DEVIATION REQUEST AND DECISION FORM

Project Name :	Crossroads North
Schedule No.(s) :	5408001008, 5408001029, 5408001032, 5408001033, 5408001034, 5408001041, 5408001042, 5408001050, 5408001051, 5408001052
Legal Description :	Lots 12, 13, 14, 15, 16 and 18, Hillcrest Acres, according to the plat thereof recorded May 12, 1960 at reception No. 153860, except that portion acquired by the department of Transportation, State of Colorado as described in rule and order recorded April 28, 2004 under reception no. 204068322, and except those portions conveyed to El Paso County by and through the Board of County Commissioners of El Paso County, Colorado by special warranty deed recorded December 17, 2014 at reception No. 214116021 and recorded December 17, 2014 at reception No. 214116022, County of El Paso, State of Colorado, Lot 17, Hillcrest Acres, County of El Paso, State of Colorado, except that portion conveyed to El Paso County by and through the Board of County Commissioners of El Paso County, Colorado by special warranty deed recorded December 30, 2014 at reception No. 214119767. Lot 19, Hillcrest Acres, County of El Paso, State of Colorado, as amended by surveyor's statement recorde

The requested deviation is for left turn lane length criteria (ECM Standard 2.3.7.E.2 & 3)

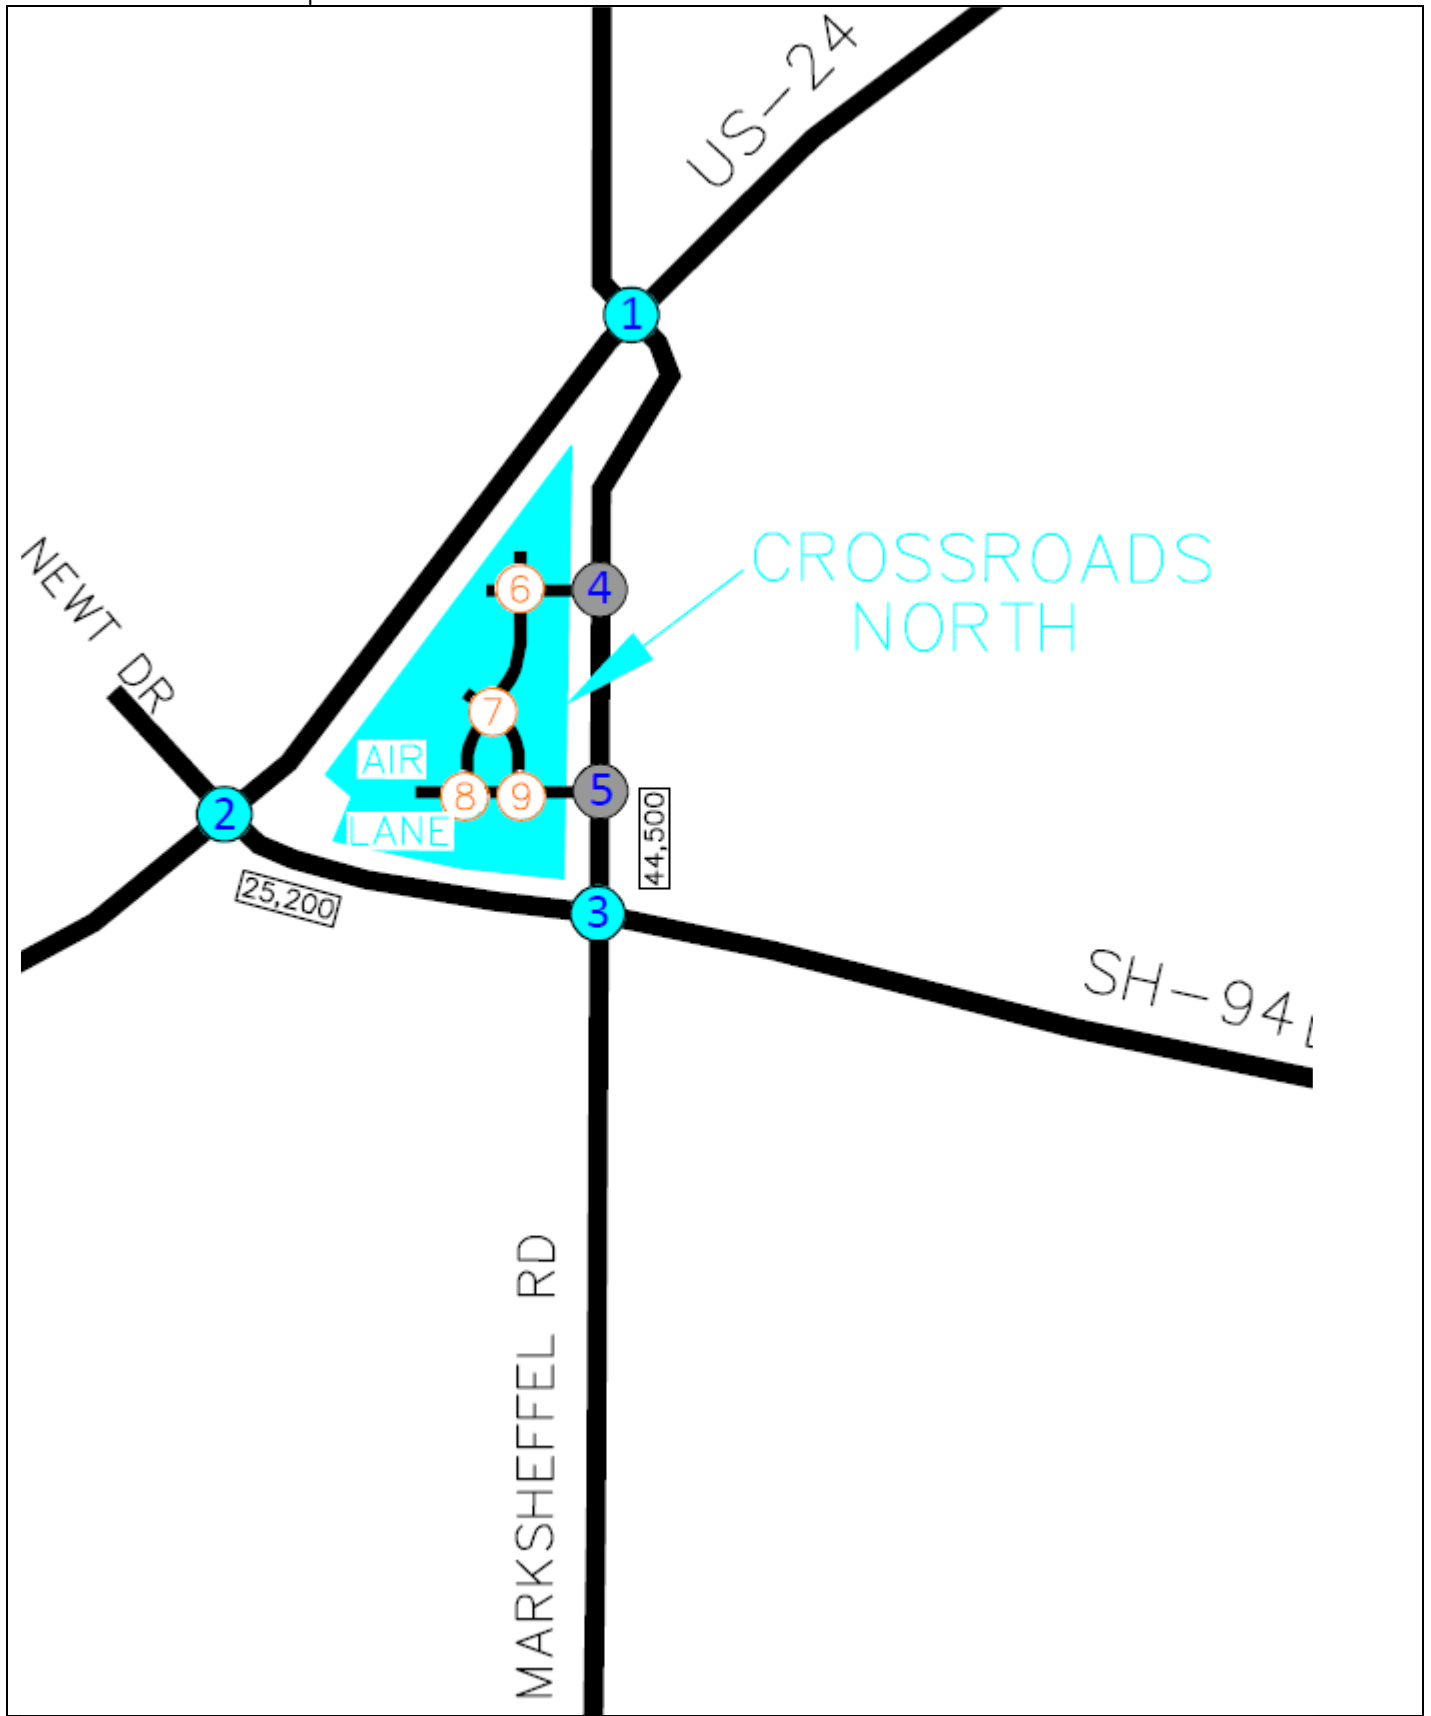
Deviation Request to be withdrawn.

After the last submittal review (Review #2) Marksheffel Road was deeded to the City of Colorado Springs for ownership/maintenance. Coordinate with City of Colorado Springs for their requirements.
